DRB Minutes, Agenda Items 6 & 7
July 28, 2021

DESIGN REVIEW BOARD

Agenda Item 6
Project Number PR-2020-004595
Applications:
SD-2021-00111 - Preliminary Plat
VA-2021-00216- Sidewalk Waiver

Agenda Item 7
Project Number PR-2020-004595
Applications:
SD-2021-00122 - Vacation of Public Easement (7')
SD-2021-00123 - Vacation of Private Easement (15')
SD-2021-00124 - Vacation of Private Easement (20')

DESIGNED BY: RJP  
 DRAWN BY: RJP  
 CHECKED BY: RJP  
 DATE: 5/20/21

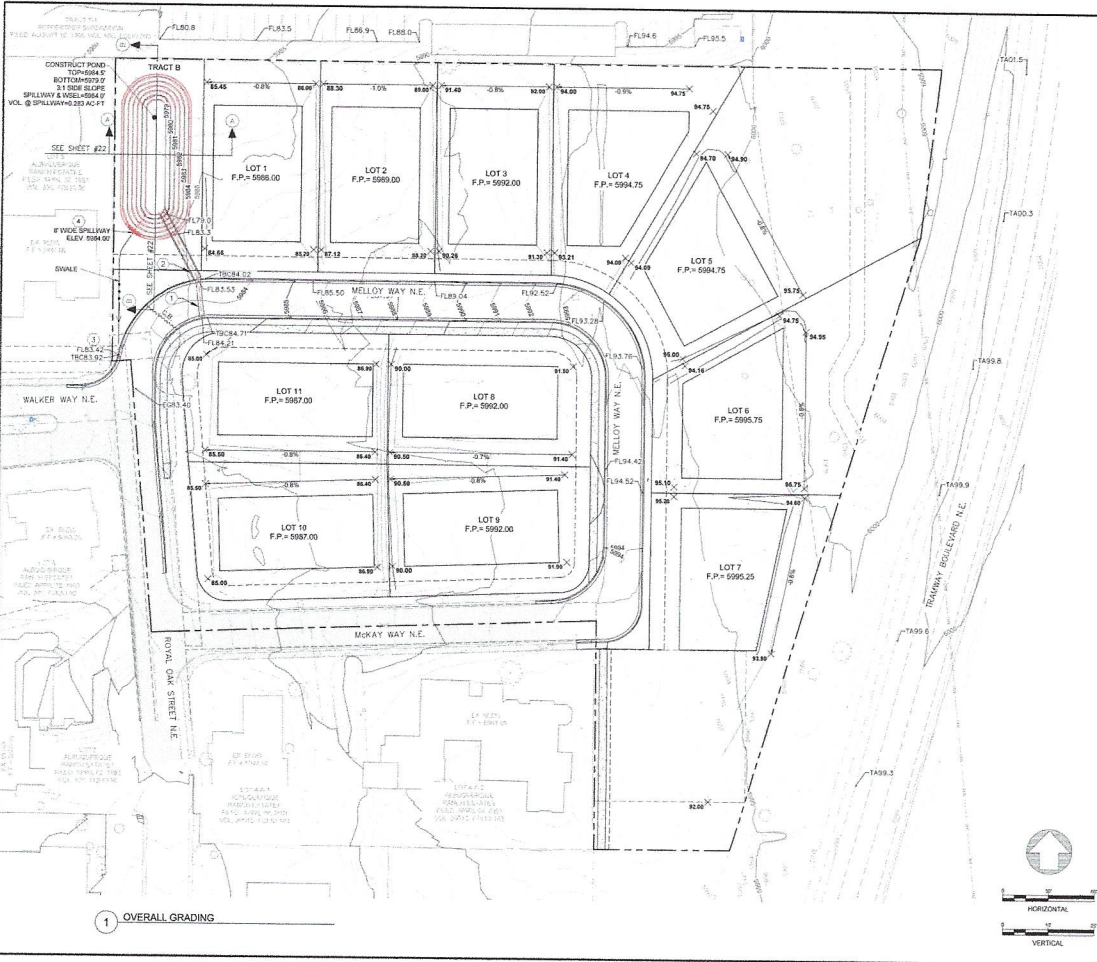
We received the revised grading plan on the 8th of July. I mentioned to Robert, currently, I will need about two weeks before I even get to it. So I won't be able to verify any of the drainage information, make sure that it's -- what's on the grading plan is on the infrastructure list. But as far as the vacations go, we have no comments on those.

PRELIMINARY PLAT OF  
**ALBUQUERQUE RANCH ESTATES, UNIT II**  
 WITHIN THE ELENA GALLEGOS GRANT  
 PROJECTED SECTION 27, TOWNSHIP 11 NORTH, RANGE 4 EAST, N.M.P.M.  
 CITY OF ALBUQUERQUE  
 BERNALILLO COUNTY, NEW MEXICO  
 MAY 2021

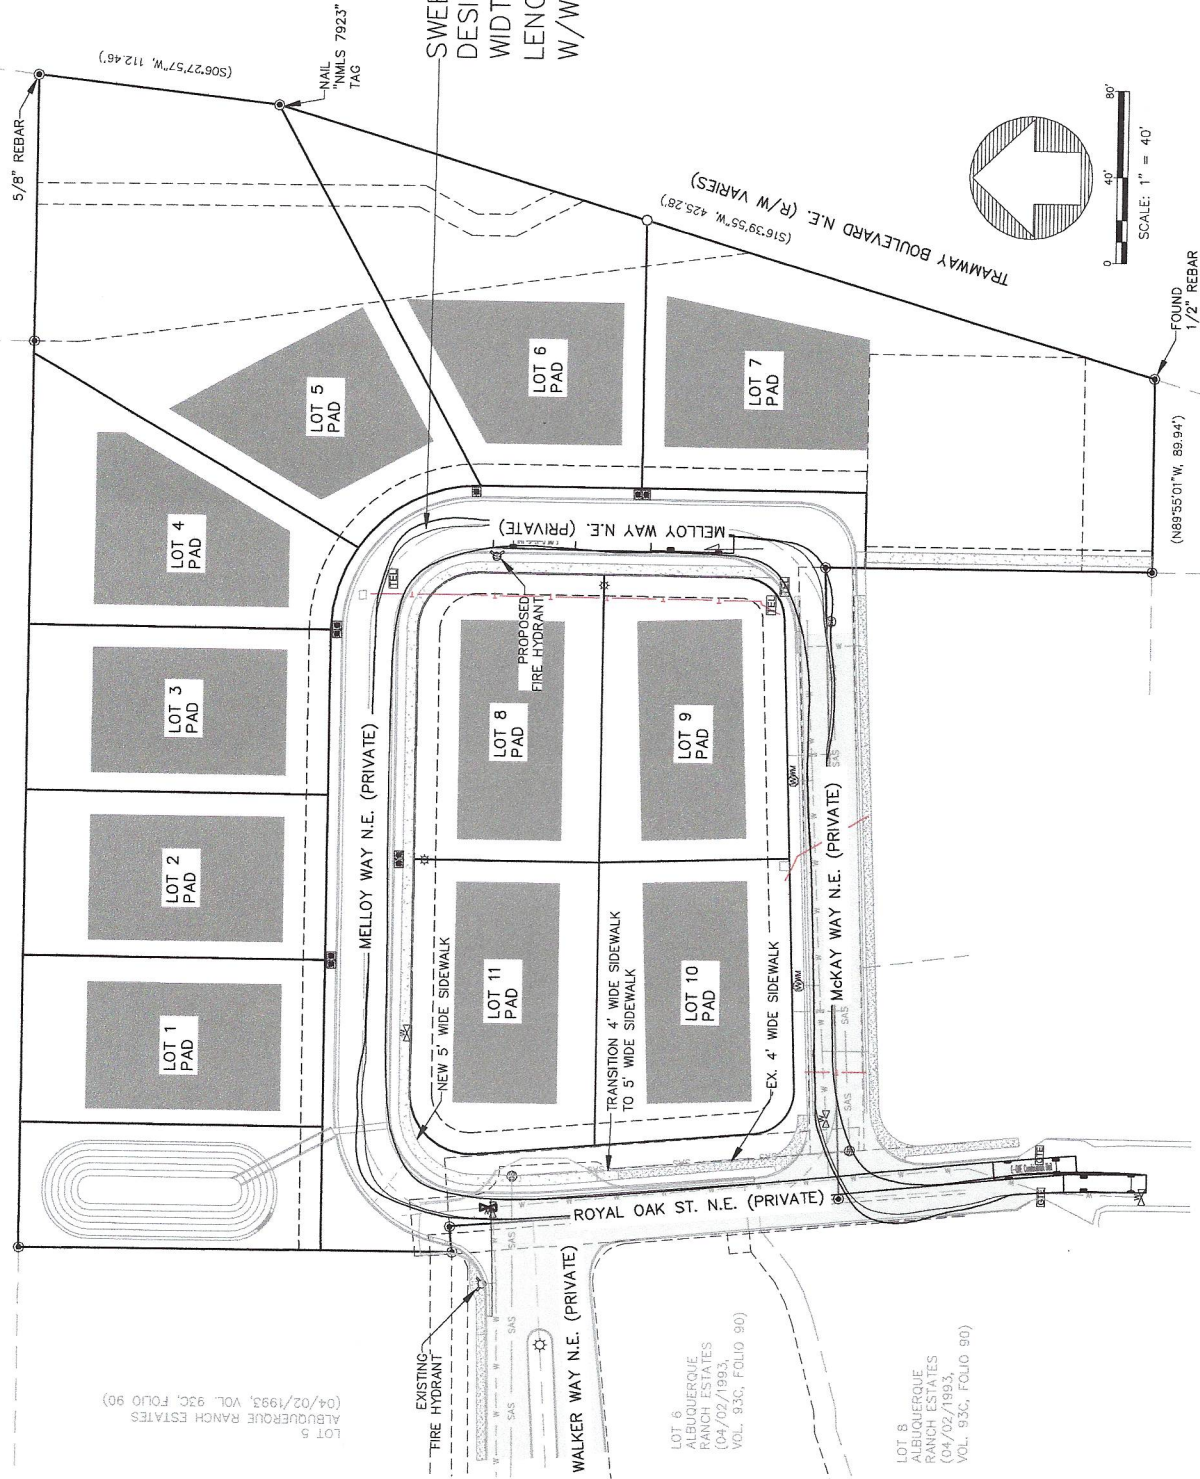
MR. CARTER: Good morning. This is Blaine Carter for the water authority. So on the preliminary plat, just a general comment that we do have (inaudible) 210213 that's been issued, provides the conditions for service. There's been approvals required and those are included in the infrastructure list. Thank you for the revisions to those, to update them as requested.

We previously noted that there's a waterline on McKay Way that was lacking a public water and public sewer easement. And that's been included on Note 3 of the latest plat we were sent. So we

just want to make sure that the city has that same plat drawing in terms of the approval request. And there's a Note 3 that references public water and public sewer.
